From: Andrew Watson [REDACTED]
Sent: 30 July 2026 16:49
To: Kathryn Welch <Kathryn.Welch@arun.gov.uk>; Hannah Keyte [REDACTED]
Cc: Brett Graham [REDACTED] Harry Chalk <Harry.Chalk@arun.gov.uk>
Subject: Re: CM/19/26/PL Baird Business Park

Subject: RE: CM/19/26/PL Baird Business Park

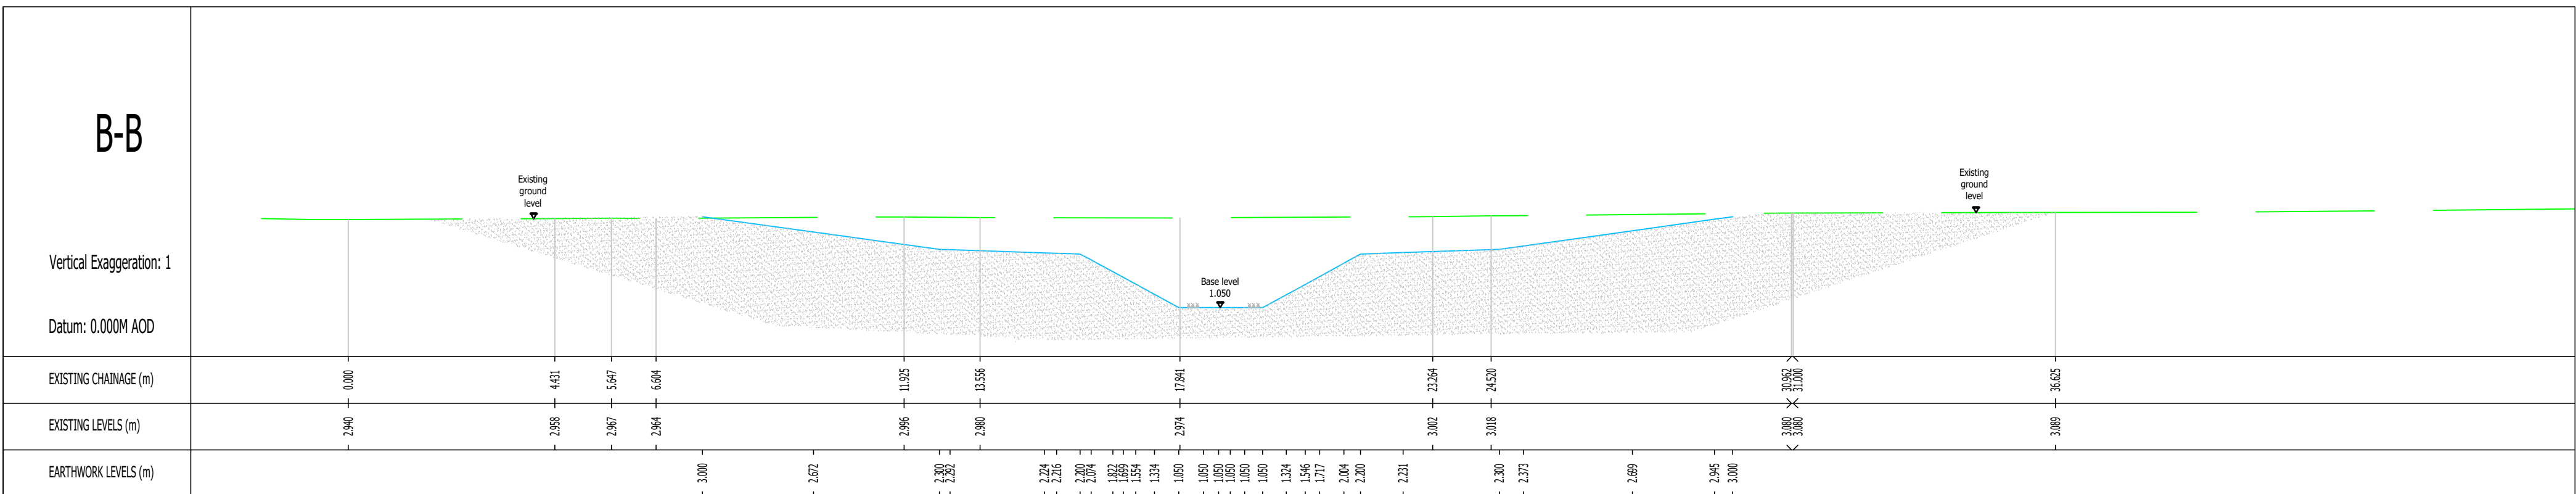
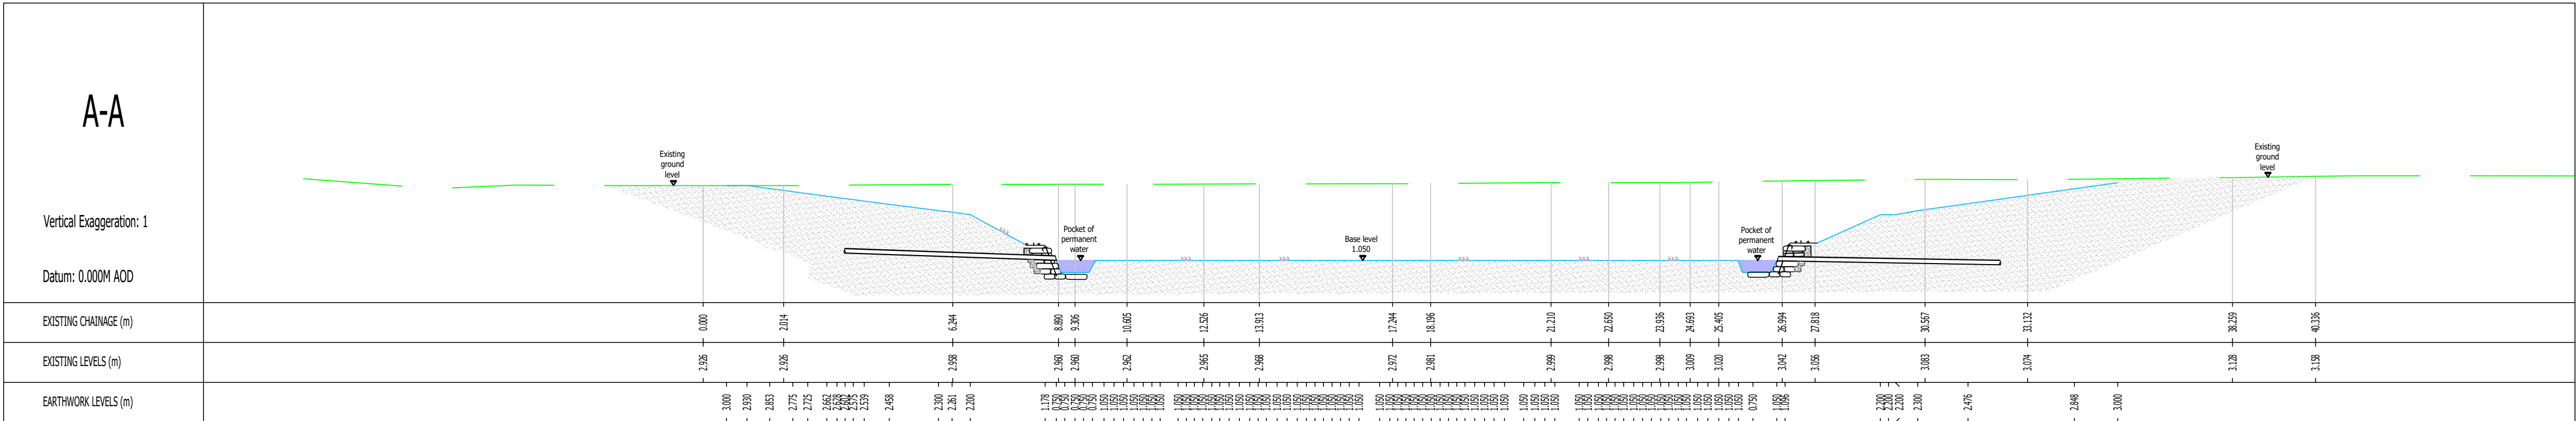
With regard to the additional commentary provided in relation to the LLFA response, could you please confirm whether any further drainage information will be submitted, or whether you intend to rely on the comments provided below by your drainage consultant?

Whilst I appreciate that some of the finer technical aspects of the drainage design can be secured through appropriately worded planning conditions, the level of detail now expected within drainage submissions is considerable. In particular, I would ordinarily expect to see detailed construction information forming part of the submitted drainage strategy, and I note that these details do not currently appear to have been provided.

1. Exceedance flows are shown on the drainage strategy drawing but they can produce a separate drawing if necessary.
2. They have defined the management responsibility in paragraph 5.22 of the FRA
3. Our understanding is that the construction level drainage information would be dealt with via an appropriately worded condition. Please can you confirm if you agree with this?

We have discussed the LLFA response further with our drainage consultant (GTA). We will provide a separate drawing showing the exceedance flow routes, notwithstanding that these are already shown on the submitted drainage strategy drawing. The proposed management responsibility is also identified at paragraph 5.22 of the submitted FRA. In addition, GTA will revise the status of the drainage strategy drawing from "Preliminary" to "Planning" to make clear that it has been prepared for planning purposes.

In relation to the request for detailed construction information, GTA has advised that construction-level drainage design would not normally be prepared at the planning application stage and cannot be finalised without the structural and detailed architectural information that will only become available during detailed design. The submitted information establishes the proposed drainage strategy and principles, with the construction-level details then capable of being secured through a suitably worded planning condition.

We therefore propose to submit the additional exceedance drawing and revised drainage strategy drawing by 20 August, but to rely upon a condition for the subsequent construction-level details. We would be grateful if this approach could be put to the LLFA when it is reconsulted. If it considers that any particular further item is essential before the application can be determined, it would be helpful for that item to be identified specifically so that our consultant can consider it.
